From: Clerk [REDACTED]
Sent: 11 September 2020 10:33
To: Planning.Responses <Planning.Responses@arun.gov.uk>
Subject: RE: Planning Consultation on: BN/74/20/PL

Application No: BN/74/20/PL

Site Address: 3 Woodside Barnham PO22 0HZ

Description of Works: Change of use of some land from public amenity land to private garden, and erect new 1.8m wooden fence with concrete posts.

Fence 3 Woodside

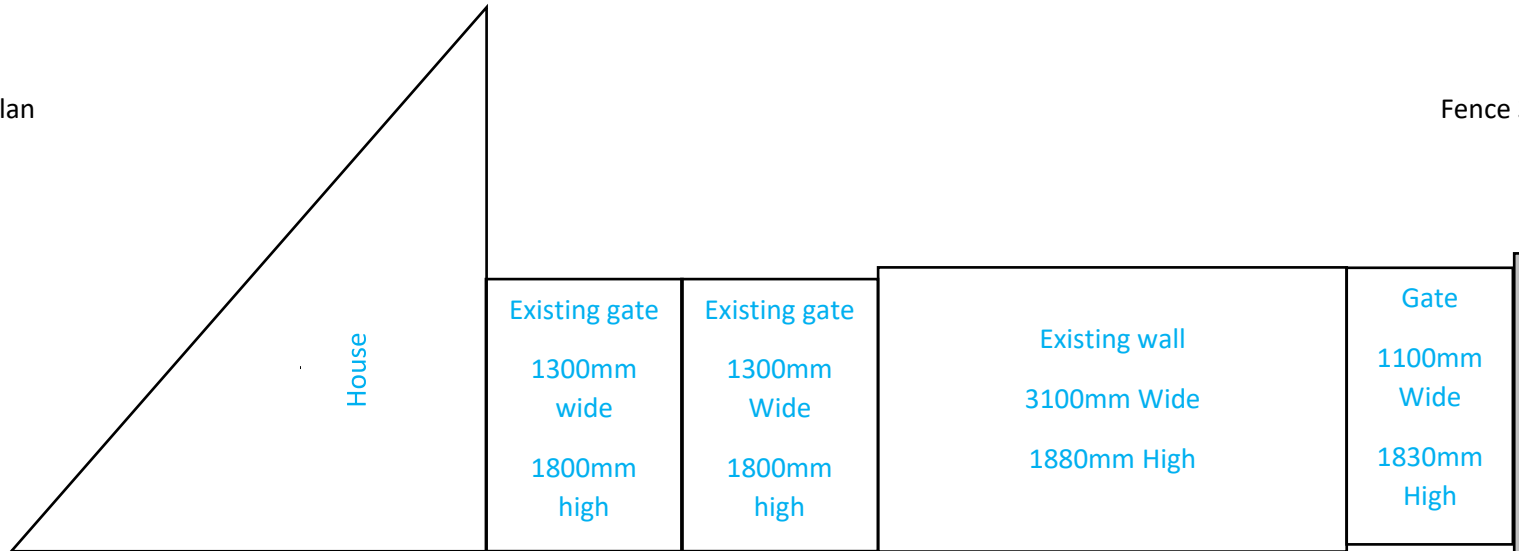
The erection of a fence of 1.9m would also impact on the visibility splay and the safety design of the junction and therefore highways should be consulted and give their view on the application.
